Subject: RE: RE - 3/2012/0402/P & 3/2012/0539/P

Regarding the application for the erection of a 50kW wind turbine (34.2m to tip height) at Mason House Farm I make the following comments:

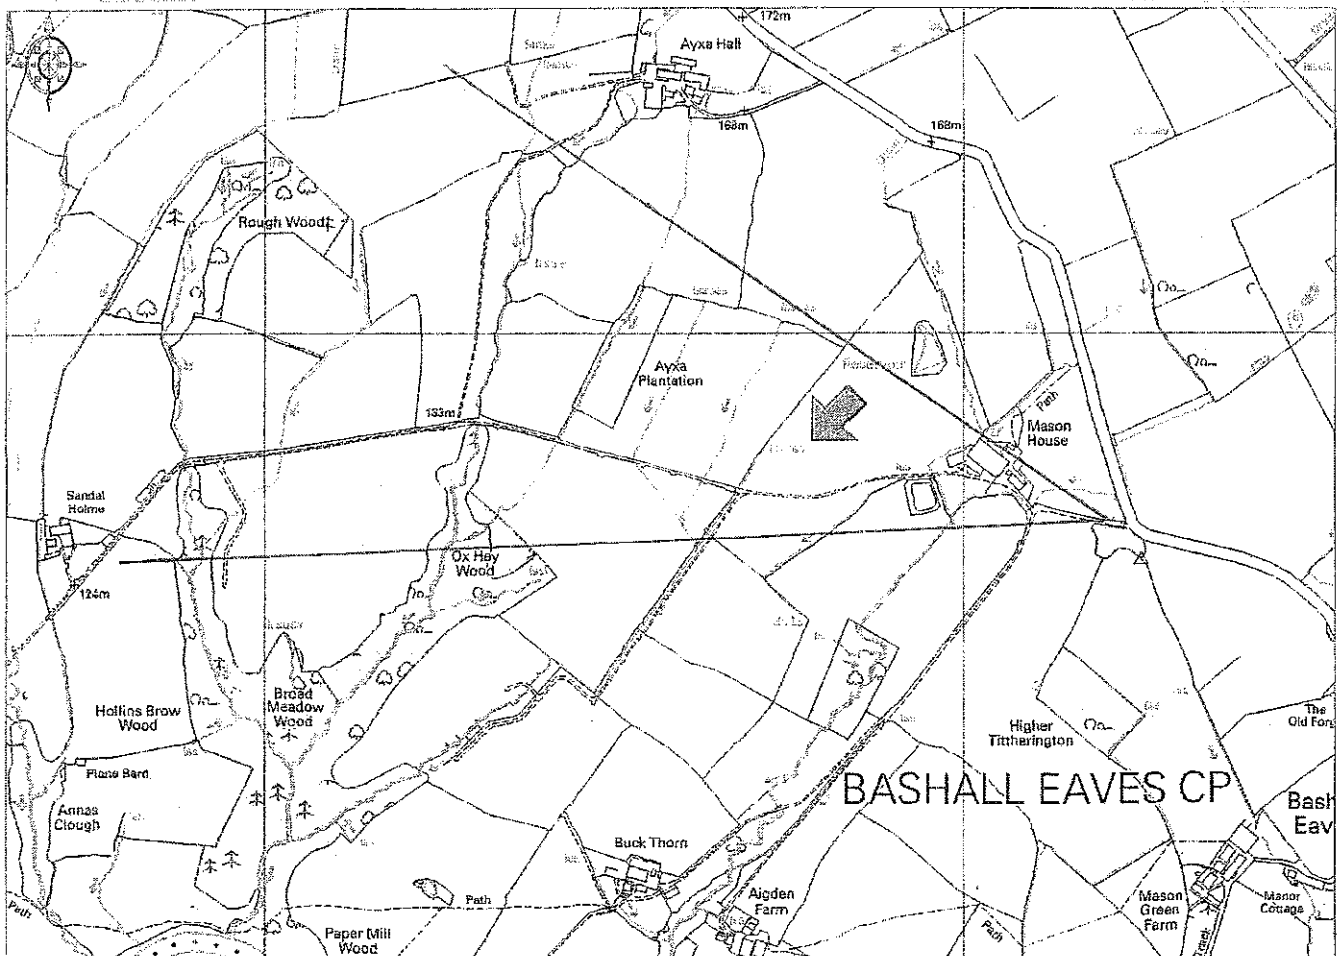
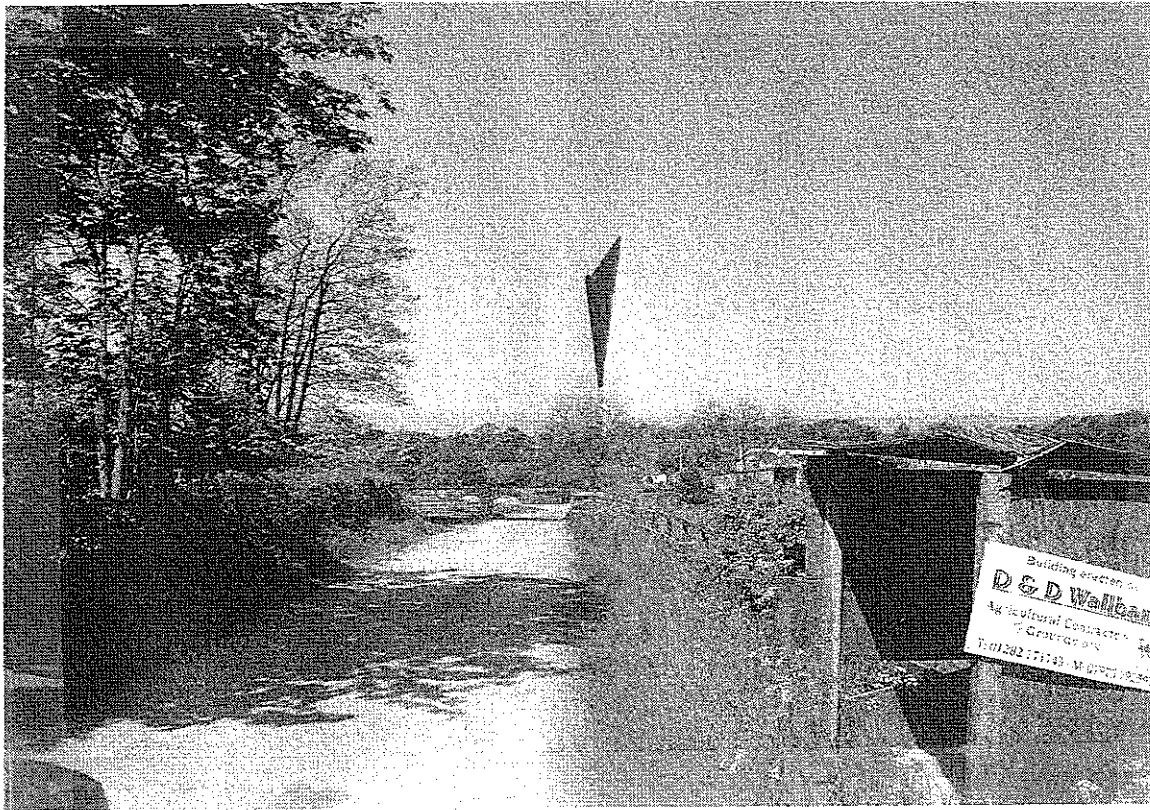
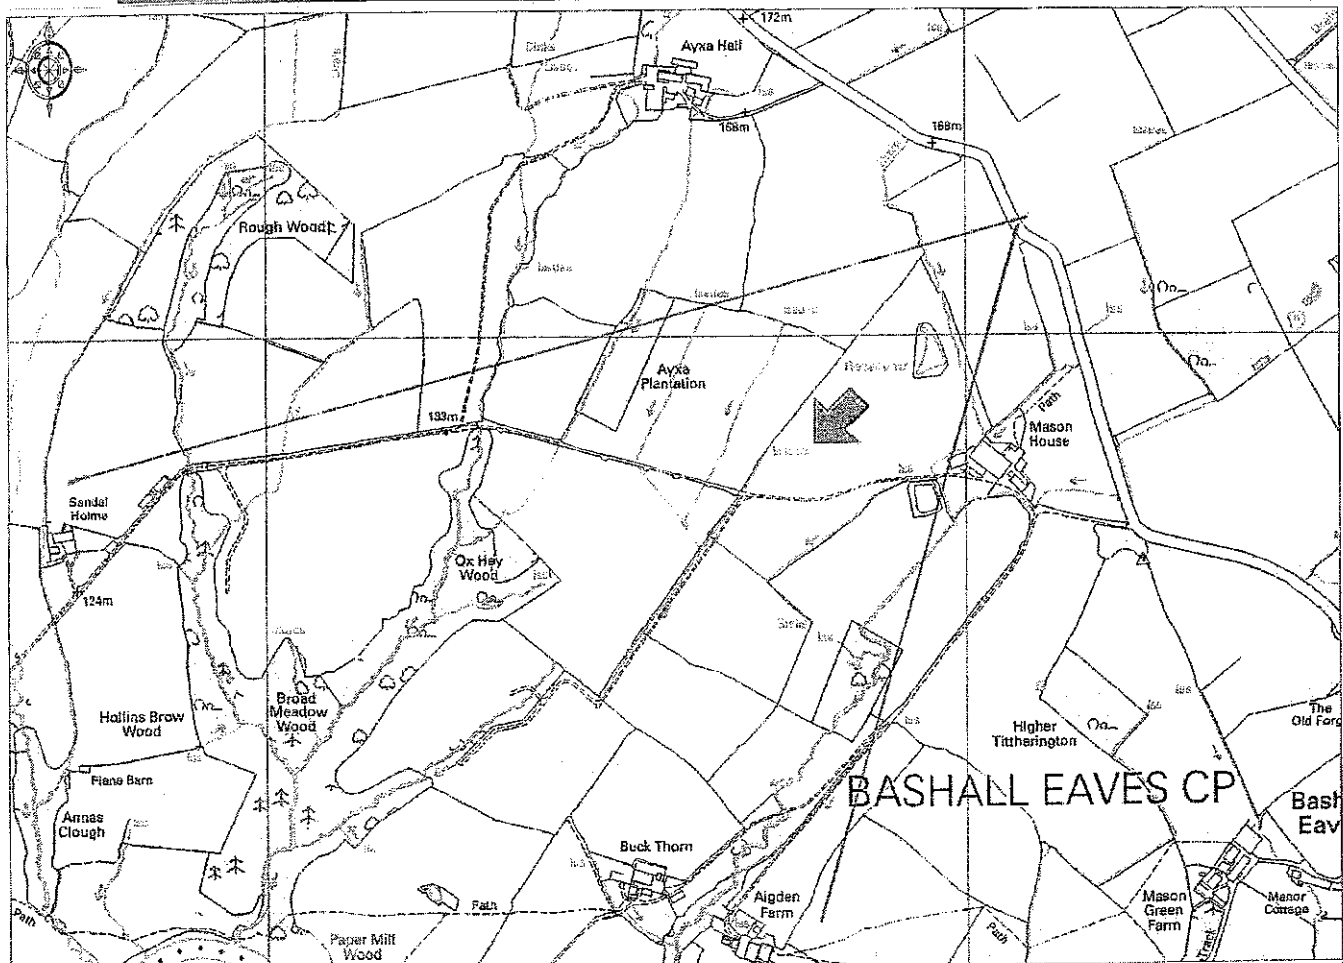
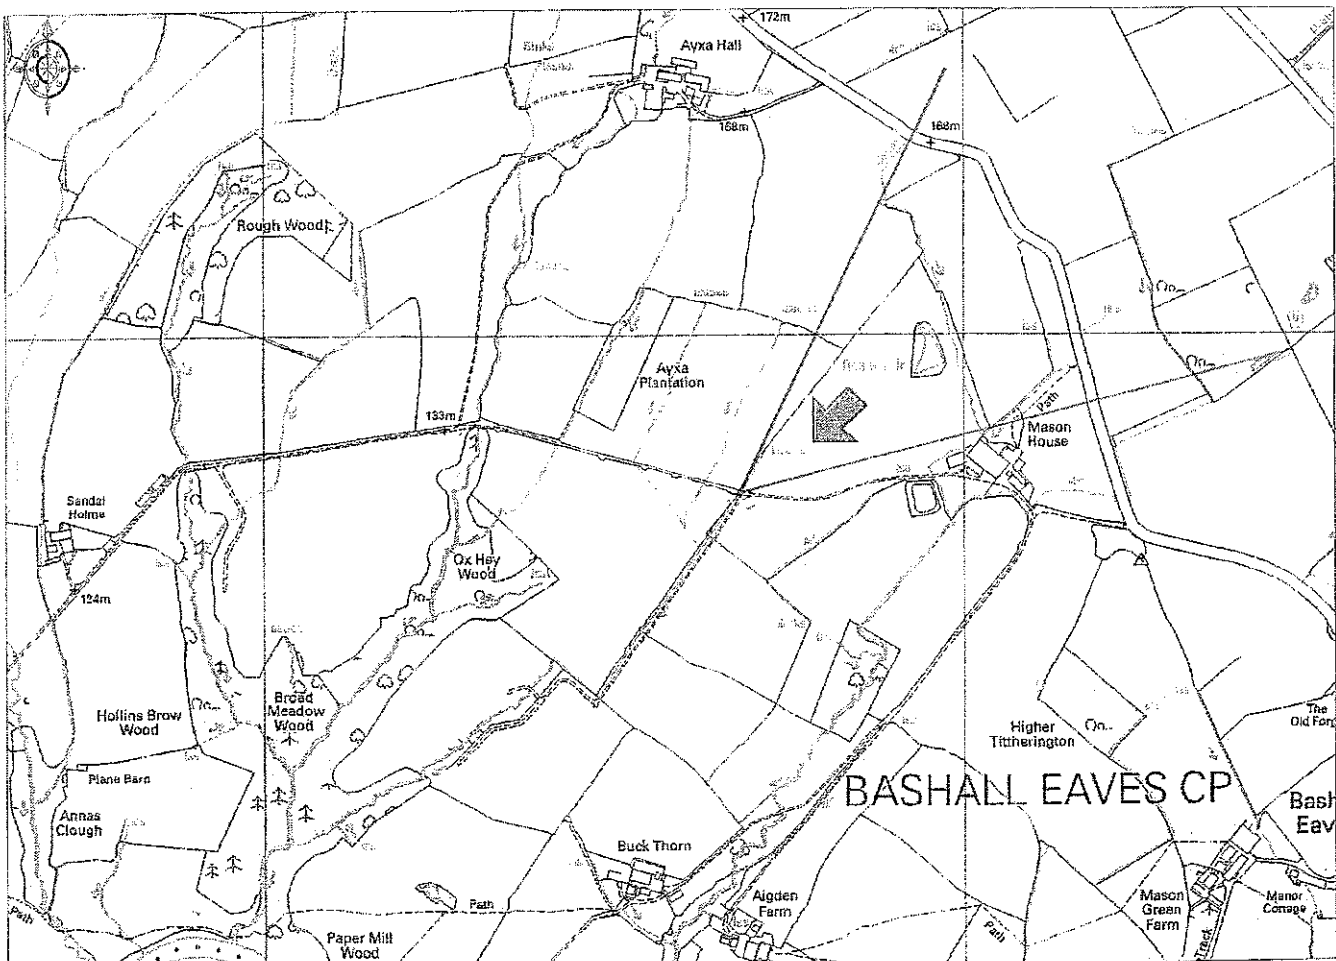
b) inadequate visualisations and zone of visual influence mapping.

No methodology detailing how the "ZVI - Map" or the visualisations were produced has been provided. Such information is essential as it helps us determine the accuracy and suitability of the maps and visualisations provided by the applicant; even something as basic as the wrong lens focal length or size of camera sensor can result in the production of extremely misleading visualisations. ZVI ('Zone of Visual Influence') mapping as produced by the applicant is intended to show the areas where the

proposed development could actually be seen, i.e. where its 'influence' would be experienced. It is essentially a refinement of Zone of Theoretical Visibility (ZTV) mapping as account is taken of vertical elements within the landscape, e.g. trees and buildings, as well as the topography when determining the extent of the proposal's visibility. Production of ZVI mapping requires the use of substantial amounts of detail about the landscape's vertical features (costly) so it is rare that ZVI maps are submitted in support of planning applications, especially ones of this size (applicants generally produce ZTV mapping in support of their wind energy development applications). Having examined the applicant's ZVI map which, has a too small study area of just 2.3km radius from the proposed wind turbine, I am not convinced that it actually shows what it is supposed to as areas are identified that would have visibility of the turbine when, due to the presence of intervening landscape features, they would in fact not. Neither the 'ZVI' map or the visualisations appear to have been produced in accordance with good practice such as that provided by Scottish Natural Heritage (*if this had been used then I am sure that there would not have been the problems outlined here*). The visualisations are a particular cause of concern as the wind turbine – where visible – appears much smaller than it would be in reality. Even the size of the wind turbine's components varies in some of the visualisations (suggesting the use of two different types of wind turbine into the images?). In addition, not even the most basic of information on how to use the visualisations, e.g. viewing distance and image size, or viewpoint/camera metadata have been provided. The choice of viewpoint locations is far from ideal as they are all within 0.5km of the proposed wind turbine; there is just too much repetition of essentially similar locations. Viewpoints are usually selected to represent a range of locations e.g. public right of way, residence, road and recreation facility, at increasing distances from the proposed wind turbine. This helps, amongst other things, to determine at what distance the wind turbine ceases to become a prominent feature in the landscape. Finally, with regard to visual information necessary for the application, I note that no data on other in-planning, consented, in-construction and operational wind energy development has been provided or mapped and there is no cumulative zone of theoretical visibility mapping.
